From: Colin Sharpe
Sent: 02 December 2011 15:27
To: Jane Tucker
Subject: FW: Consultation on planning application 3/2011/0833 Prestons Yard, Longridge Road, Chipping

From: Hornby, Mark [mailto:Mark.Hornby@lancashire.gov.uk]
Sent: 02 December 2011 14:39
To: Colin Sharpe
Cc: ENV EPP Customer Service Area East
Subject: RE: Consultation on planning application 3/2011/0833 Prestons Yard, Longridge Road, Chipping

Based on the revised site layout with a minimum 6.6m driveway length I now have no objection to this proposal, subject to the following conditions:

Proposed Layout Ground Floor

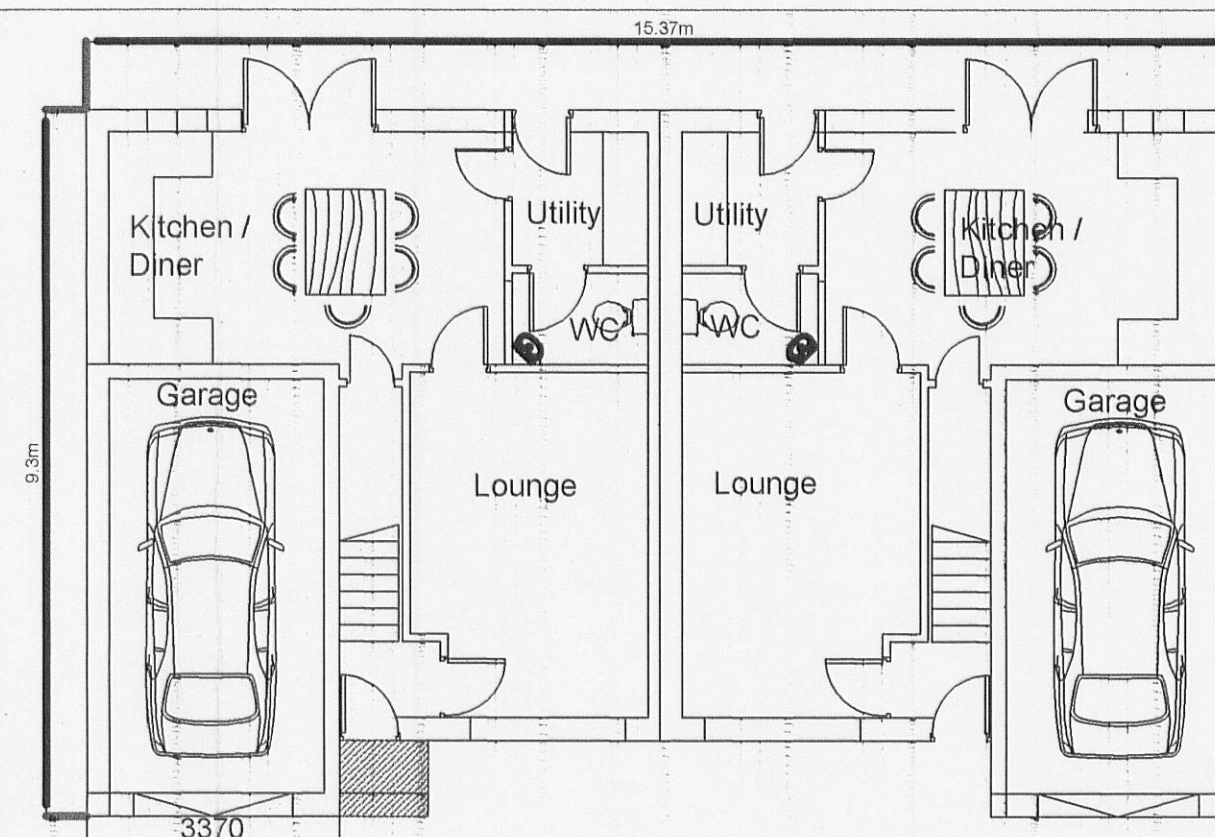
1. The access driveways to the proposed development shall remain ungated.
Reason: To permit vehicles to pull clear of the carriageway when entering the site and to assist visibility.
2. Before the access driveways are used for vehicular purposes they shall be appropriately paved in tarmacadam, concrete, block pavements, or other approved materials. Reason: To prevent loose surface material from being carried onto the public highway thus causing a potential source of danger to other road users.
3. There shall not at any time in connection with the development be erected or planted or allowed to remain upon the land hereinafter defined any building, wall, fence, hedge, tree, shrub or other device.

The visibility splay to be the subject of this condition shall be that land in front of a line drawn 3.5 metres measured back from the edge of the carriageway of Longridge Road along the entire frontage of the development. This land consists of the proposed 1.5 metre pedestrian footway and the first 2.0 metres of the proposed properties, and shall be maintained at footway level in accordance with a scheme to be agreed by the Local Planning Authority in conjunction with the Highway Authority. Reason: To ensure adequate visibility at the site access.
